**Technical Consultation No 1 for Planning Application Ref: APP/2023/2333**

Proposal **Erection Of Dwellinghouse For Holiday Let**  
:

Location: **Site At Colliestown Farm Torphins Banchory Aberdeenshire AB31 4JN**

Colliestown Farm Torphins	
Accommodation Unit	
Site Plans	
Date : May 2023	Drawing No.
Scale : As Shown @ A1	2021-128/P01
Drawn : AR	
<b>Gerry Robb</b> architectural design services	
Bridgend Bridgeview Road Aboyne Aberdeenshire AB34 5HB (013398) 86359 info@gerryrobb.co.uk

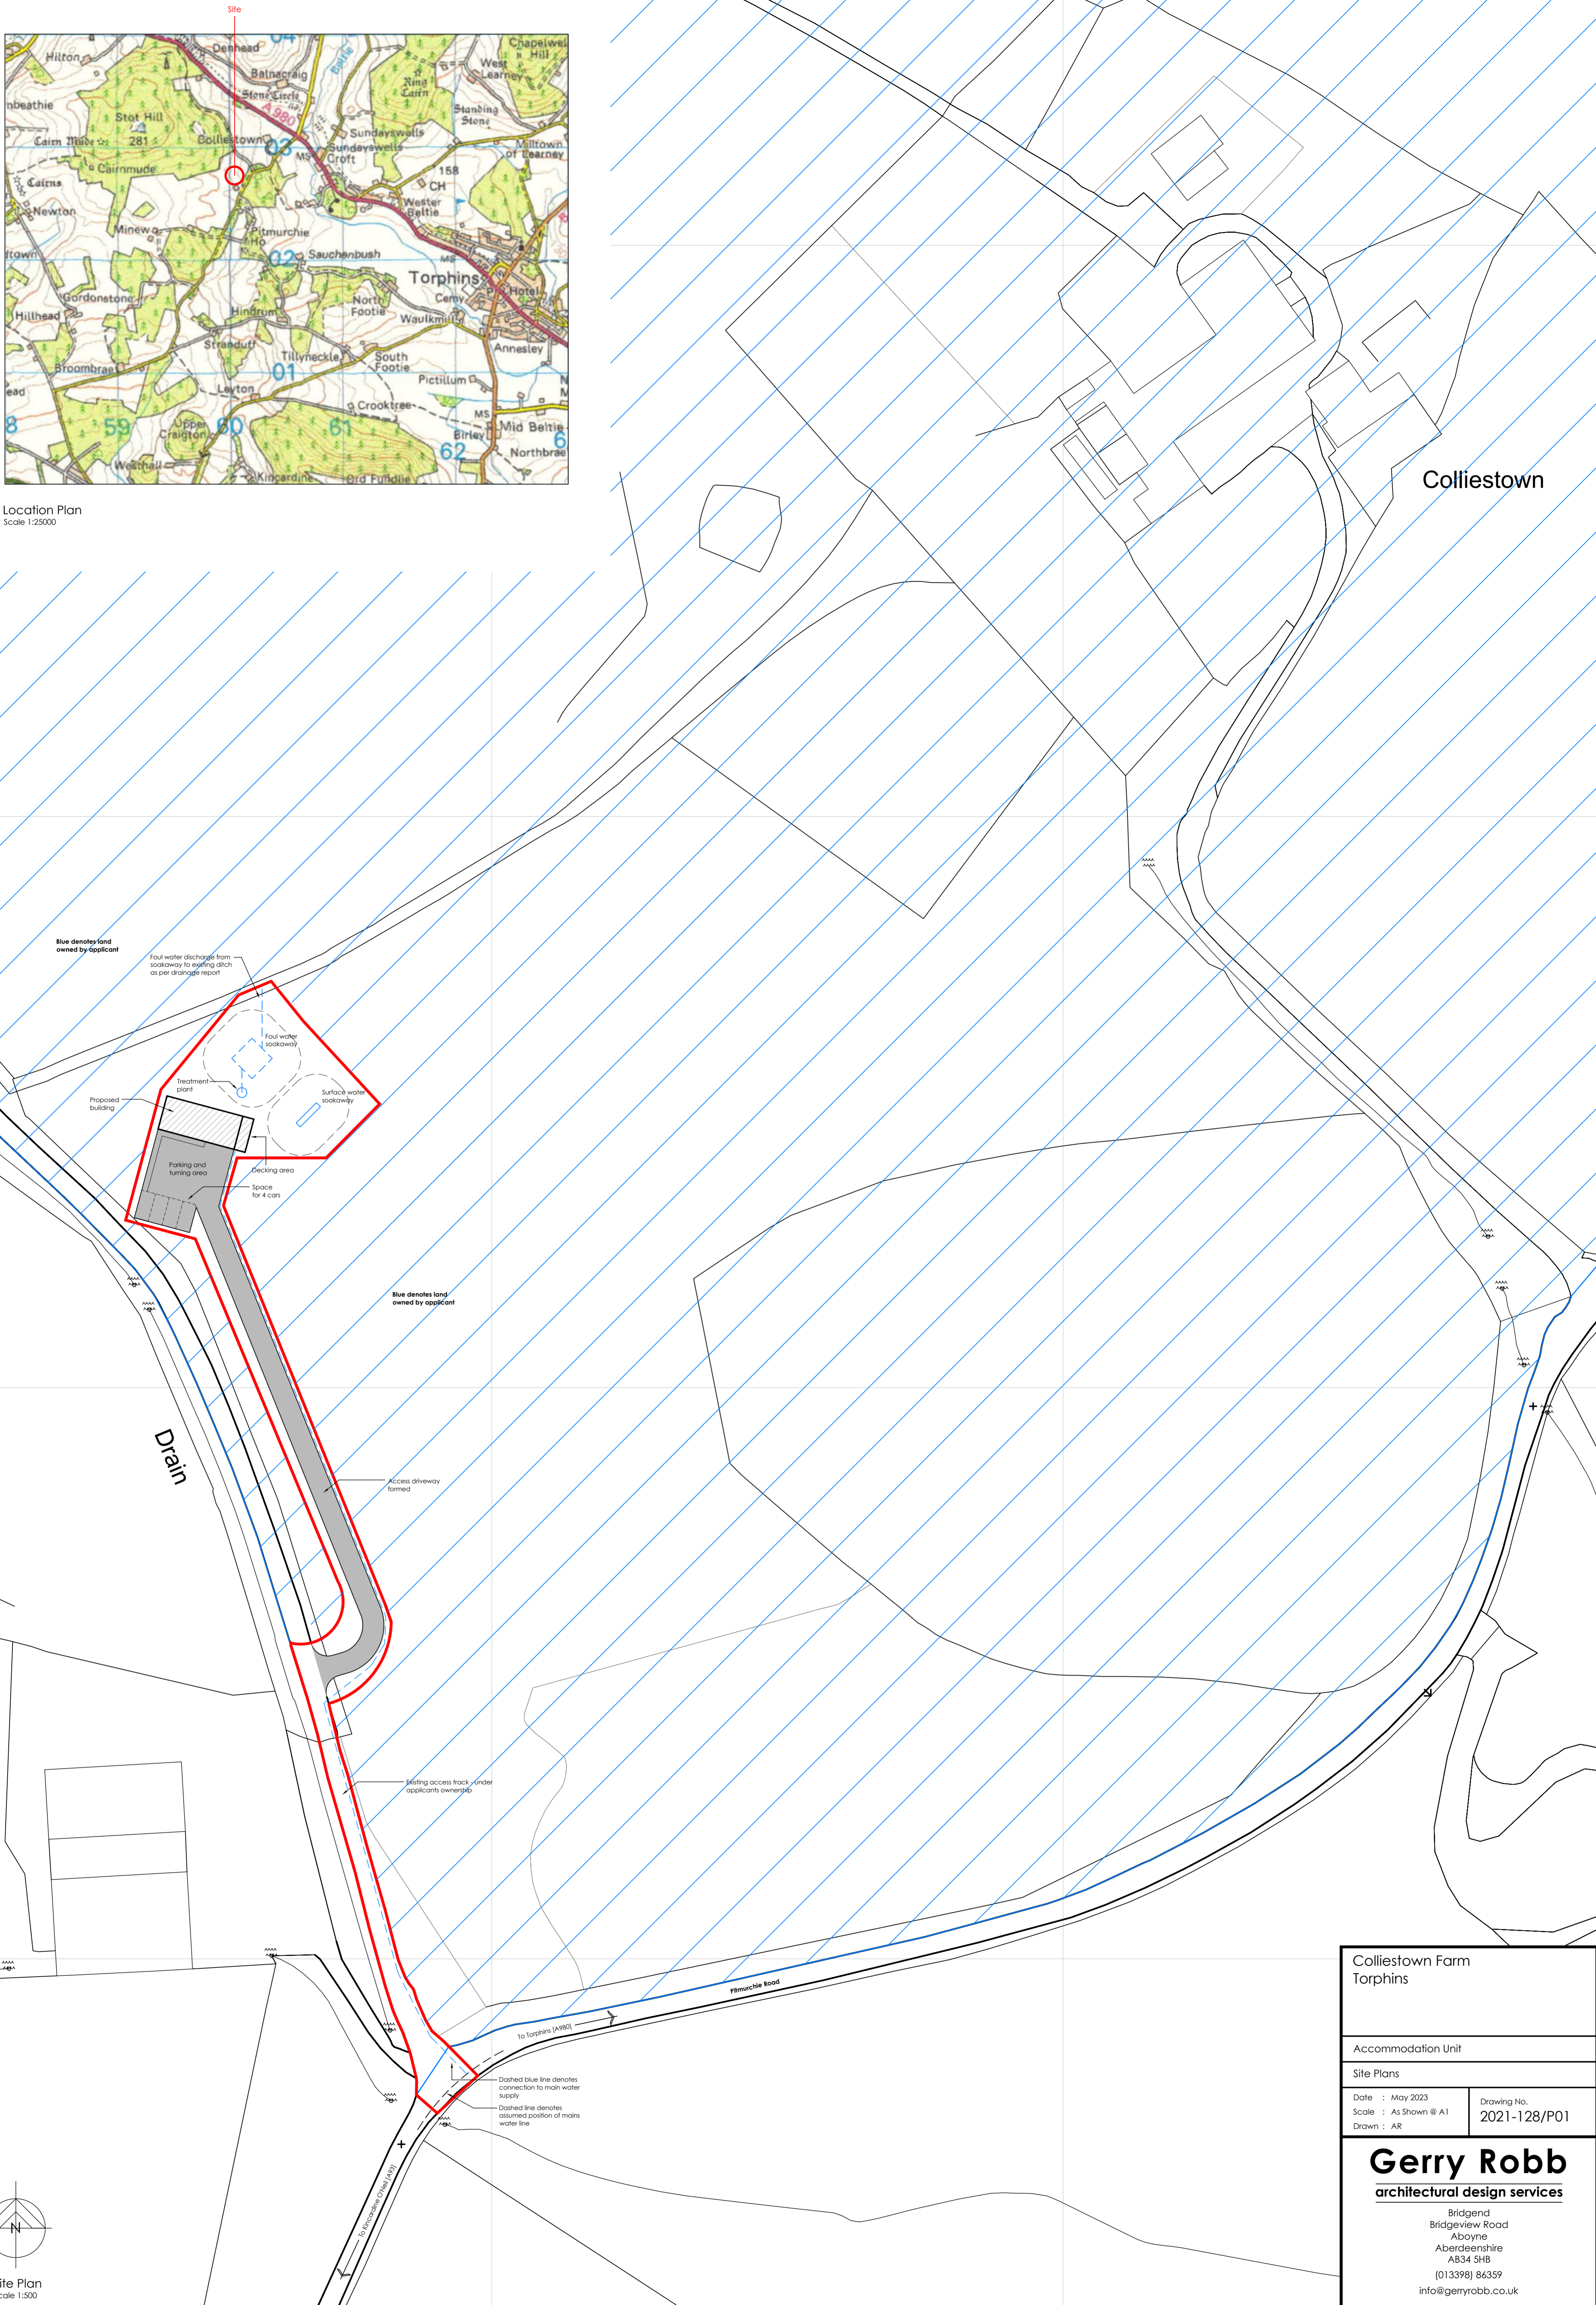
Visibility should be achievable if roadside vegetation is maintained.

- Prior to commencement of development, Visibility Splays, measuring 2.4m by 90m to be formed on either side of the junction of the vehicular access with the public road. The visibility splays so formed shall thereafter be kept free of all permanent obstructions above adjacent carriageway level.
